PR-2018-001499

SD-2024-00139 – PRELIMINARY PLAT

Project: McMahon Commons
Lot/Tract A
McMahon Blvd. & Universe Blvd. Agenda Item No: 1

Project Name: McMahon Commons. East of McMahon & Universe.

**PLAT OF
TRACTS A-1, A-2, A-3 & A-4
MCMAHON COMMONS
SITUATE WITHIN
PROJECTED SECTION 3, T. 11 N., R. 2 E., N.M.P.M.
TOWN OF ALAMEDA GRANT
CITY OF ALBUQUERQUE
BERNALILLO COUNTY, NEW MEXICO
FEBRUARY 2024**

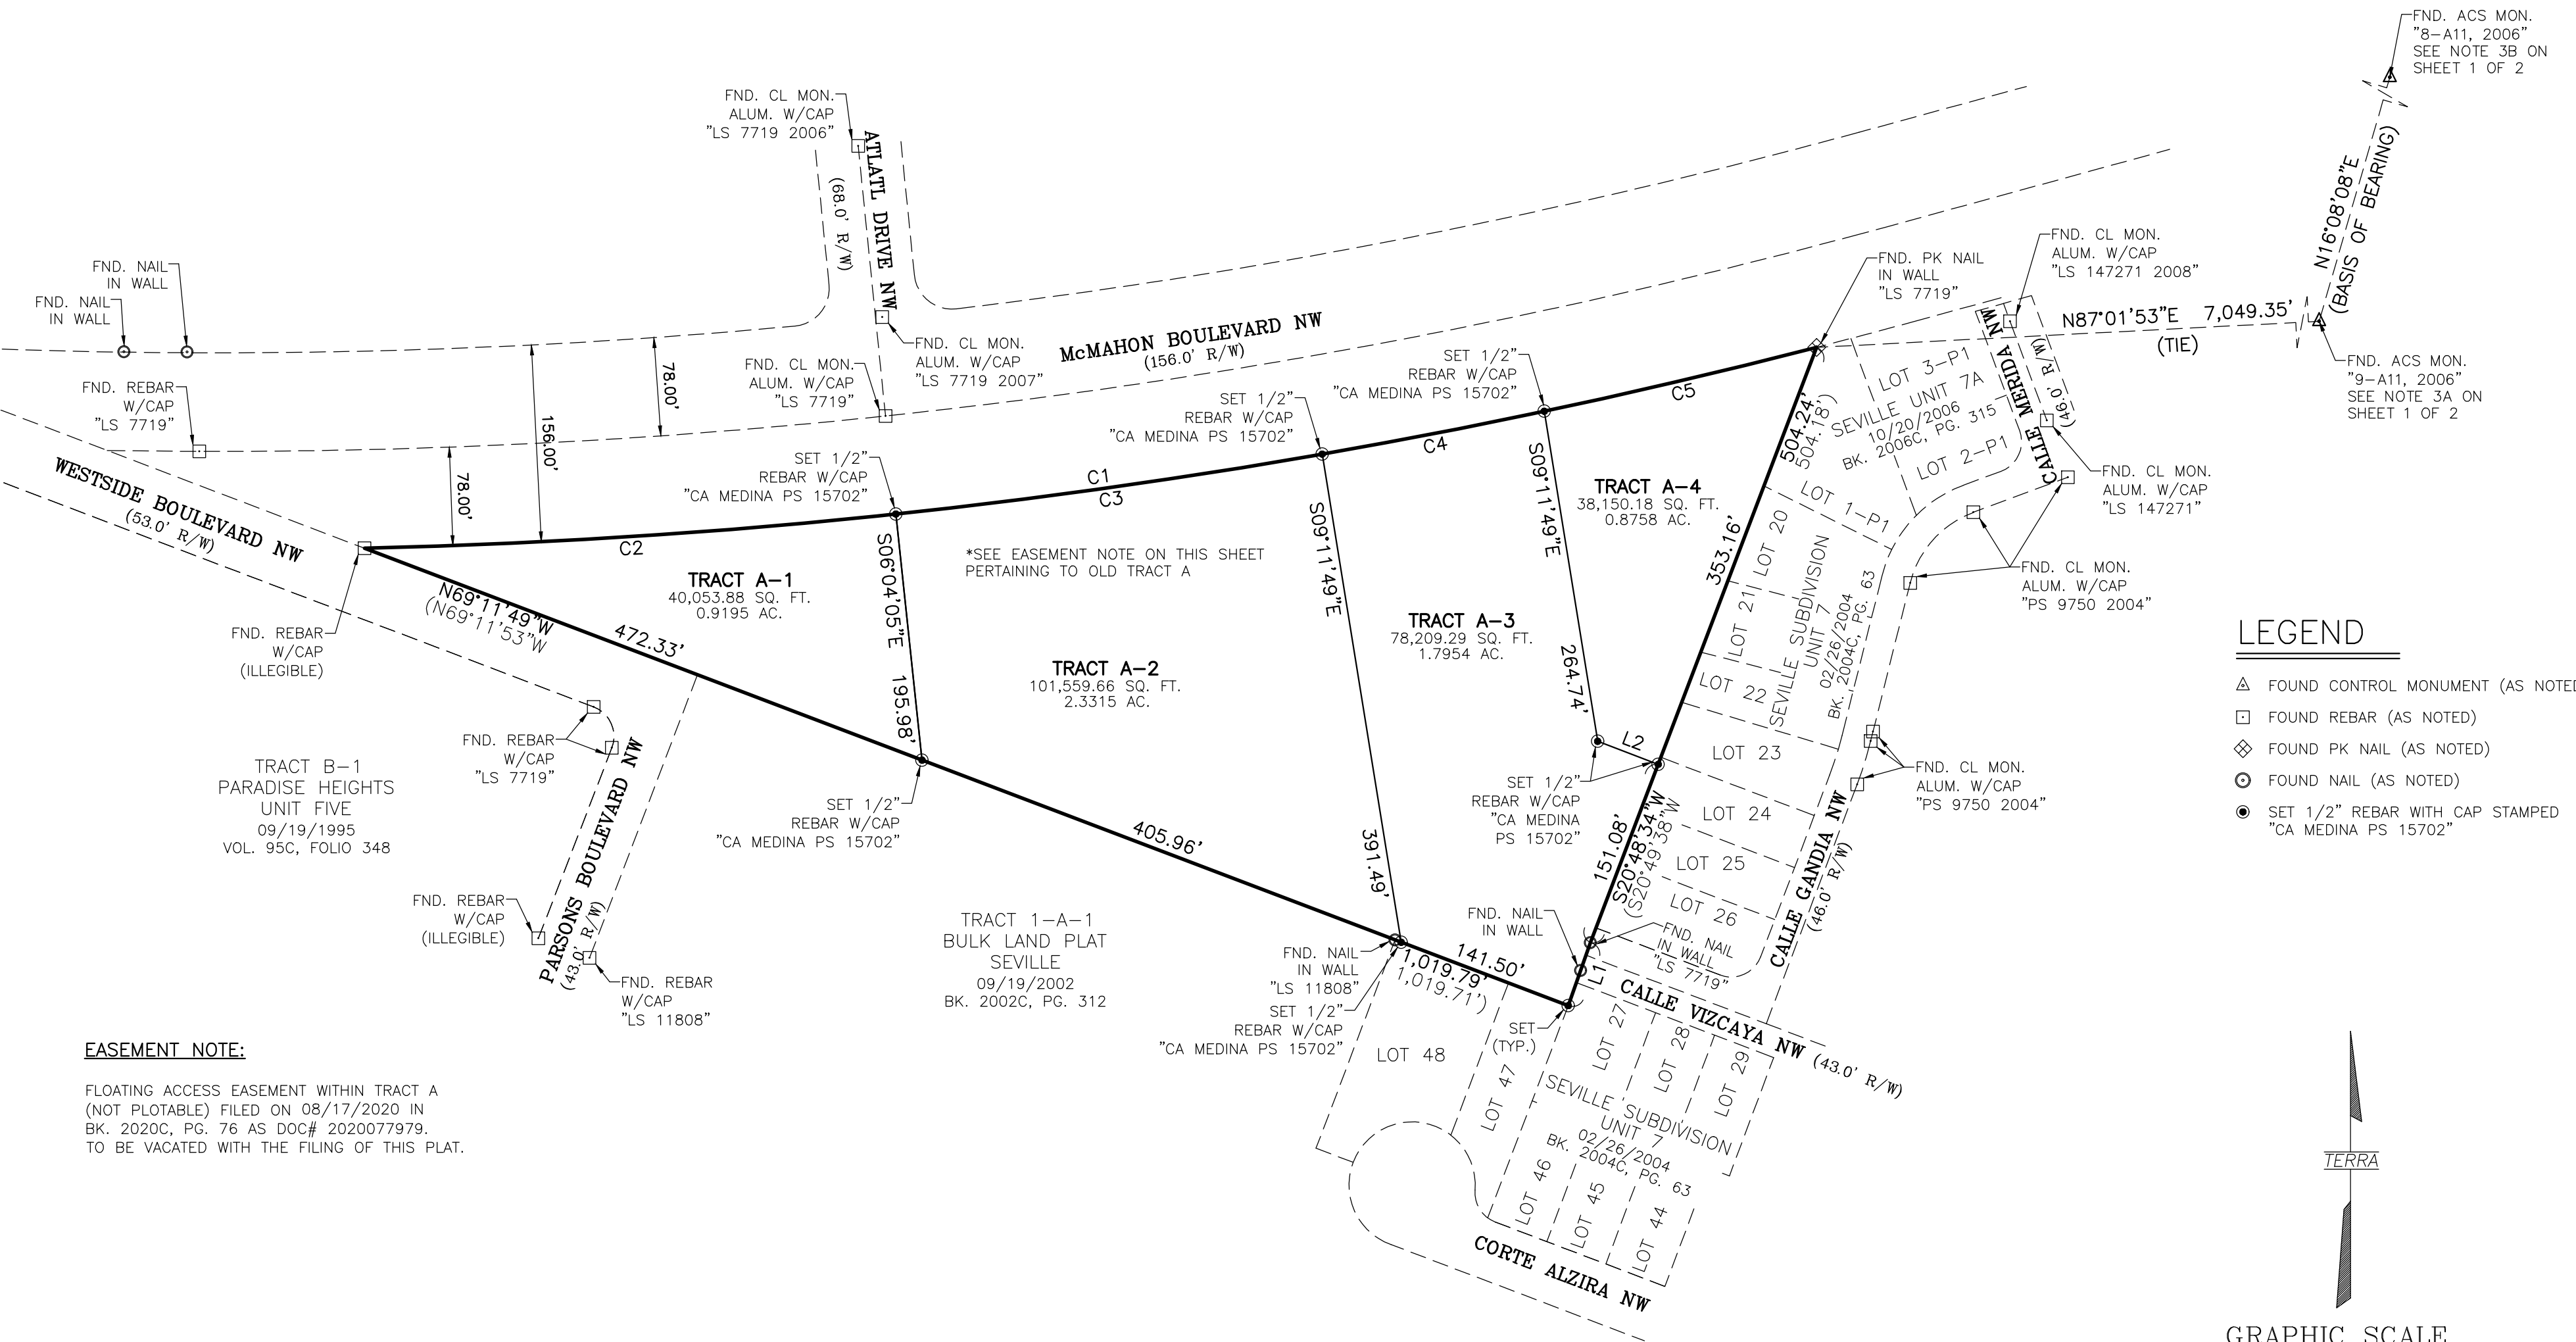
1. Will require edge and height buffering along the residential lots.

- The infrastructure list will be needed for Preliminary Plat for offsite improvements.
- A recorded SIA is required prior to Final Plat.
- Add a Cross Lot Drainage Easement note specifying the beneficiary and maintenance agreement.

- Add a Public Drainage Easement over the Storm Water Quality Pond at the NE portion of the site.
- Since this project drains into an Albuquerque Metropolitan Arroyo and Flood Control Authority (AMAFCA) facility, approval by AMAFCA for the Grading and Drainage Plan will be needed prior to Hydrology approval of Building Permit, Grading Permit, and SO-19/Work Order Permit. Please contact Jared Romero P.E, CFM (jromero@amafca.org or 505-884-2215).

PLAT OF  
TRACTS A-1, A-2, A-3 & A-4  
MCMAHON COMMONS  
SITUATE WITHIN  
PROJECTED SECTION 3, T. 11 N., R. 2 E., N.M.P.M.  
TOWN OF ALAMEDA GRANT  
CITY OF ALBUQUERQUE  
BERNALILLO COUNTY, NEW MEXICO  
FEBRUARY 2024

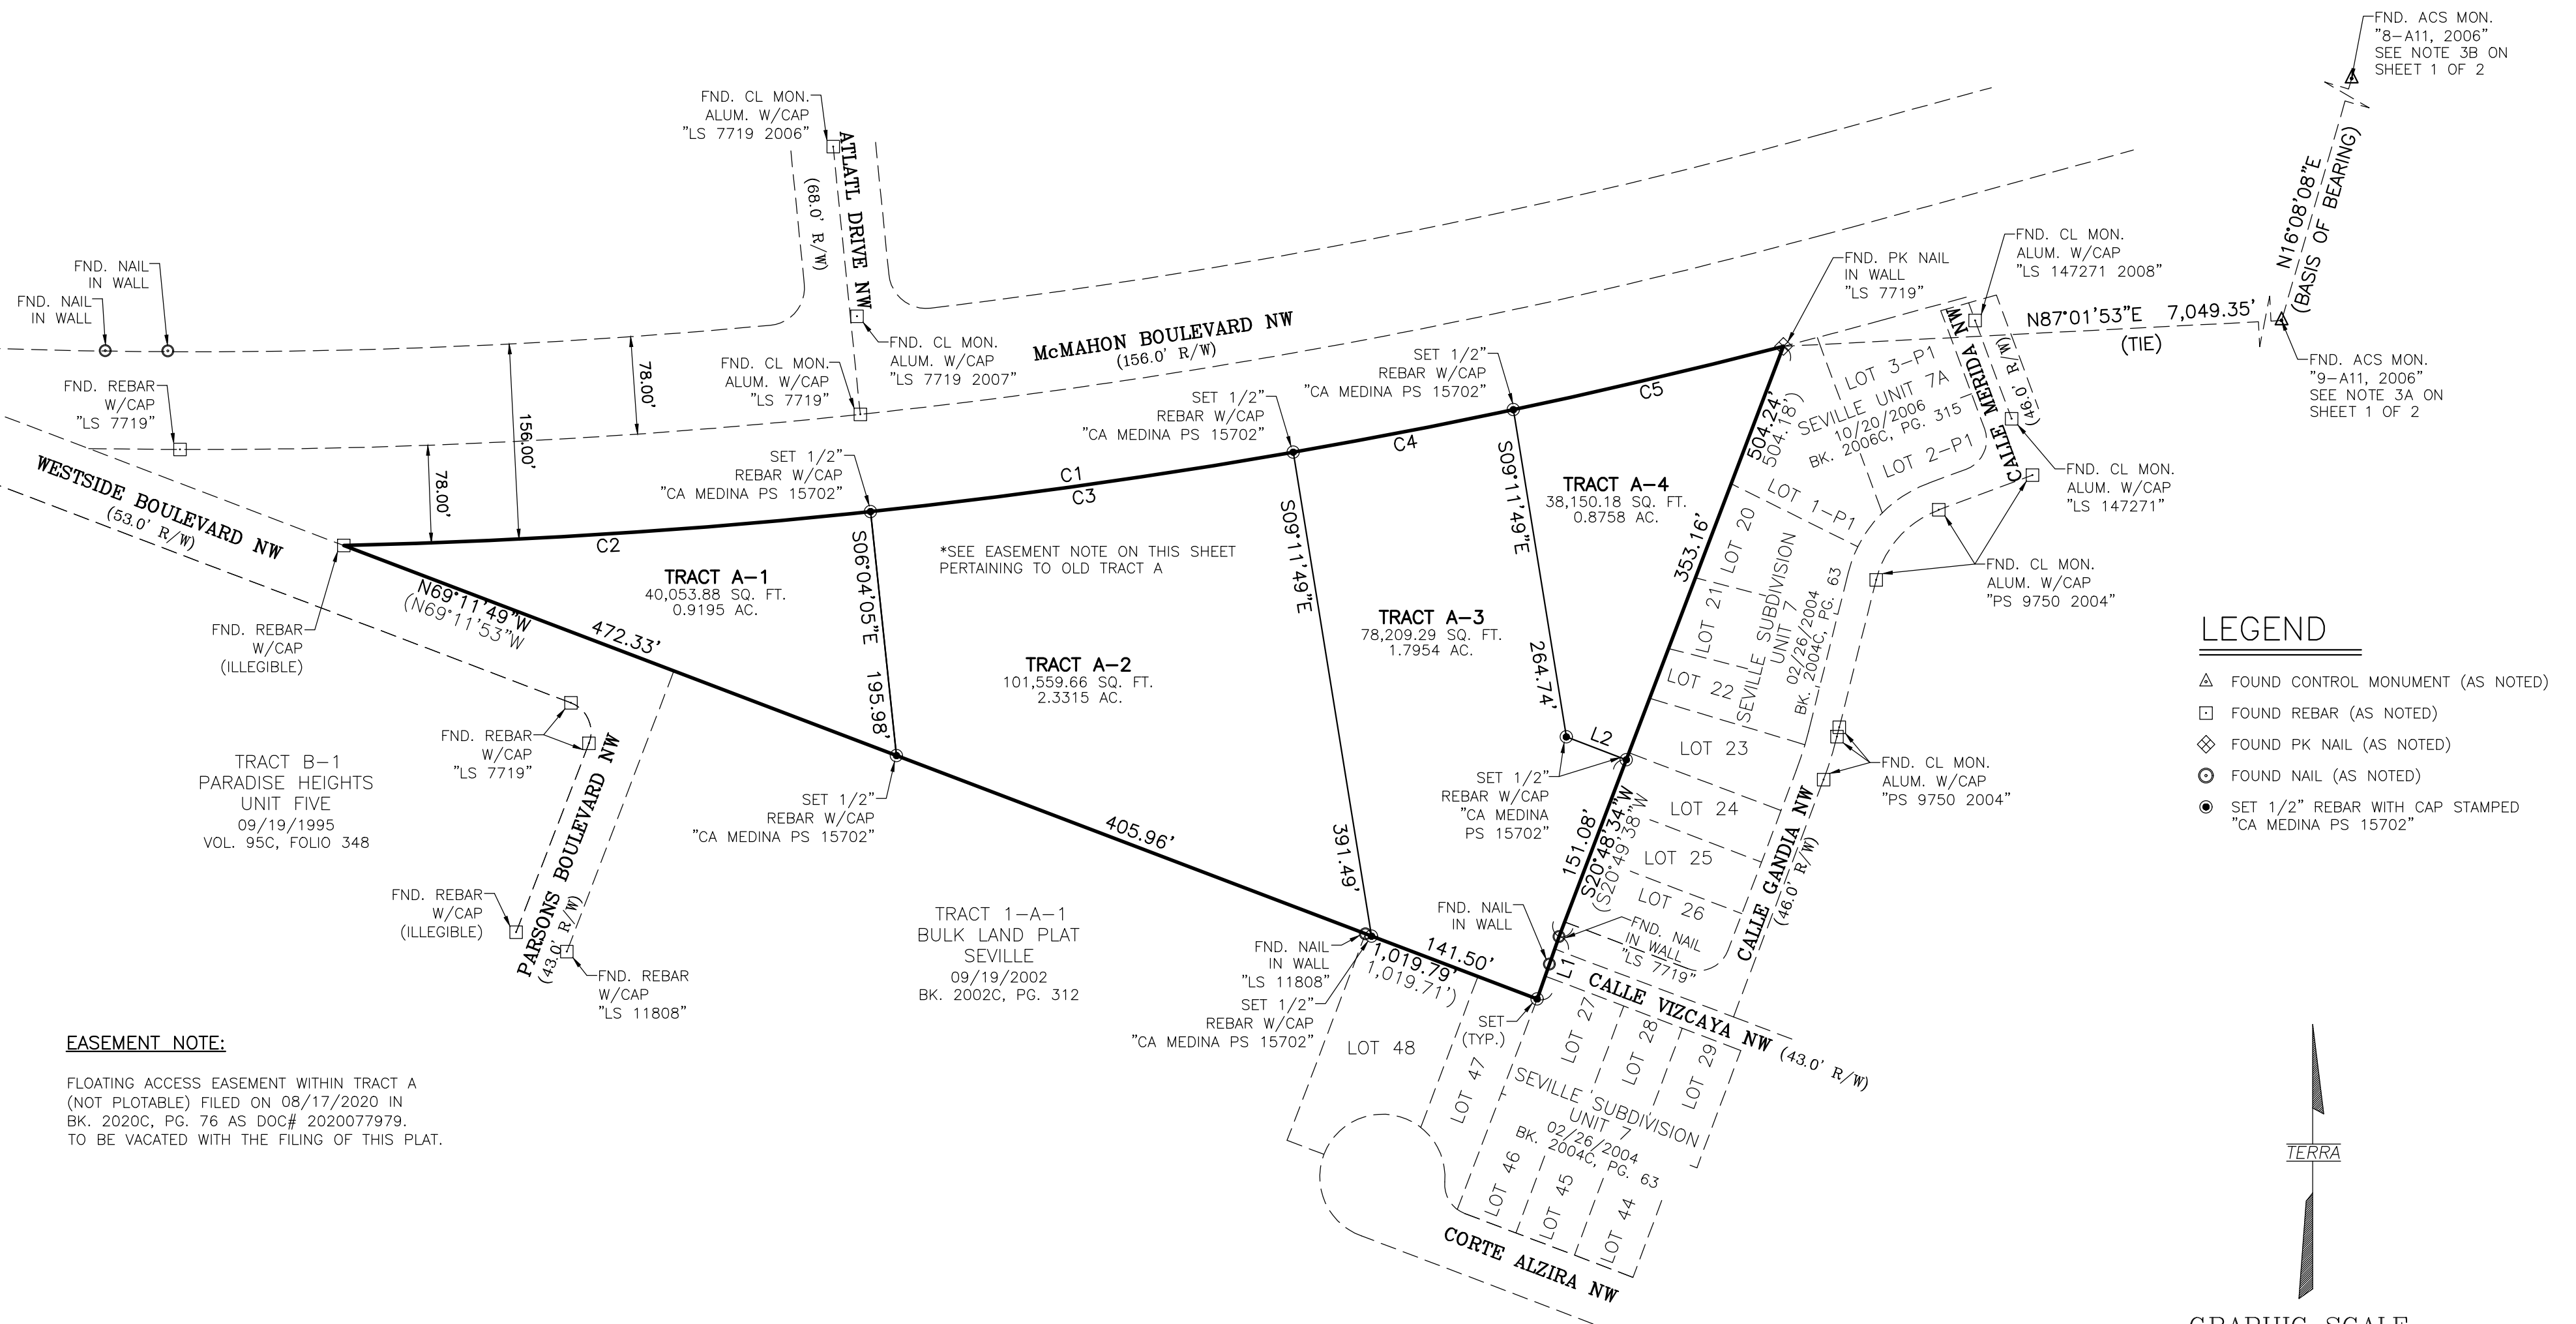
Westside is a local roadway and will need to be constructed along the frontage of this property with 5' sidewalk and a 4-6' landscape buffer. The infrastructure for this roadway was not addressed with this application.
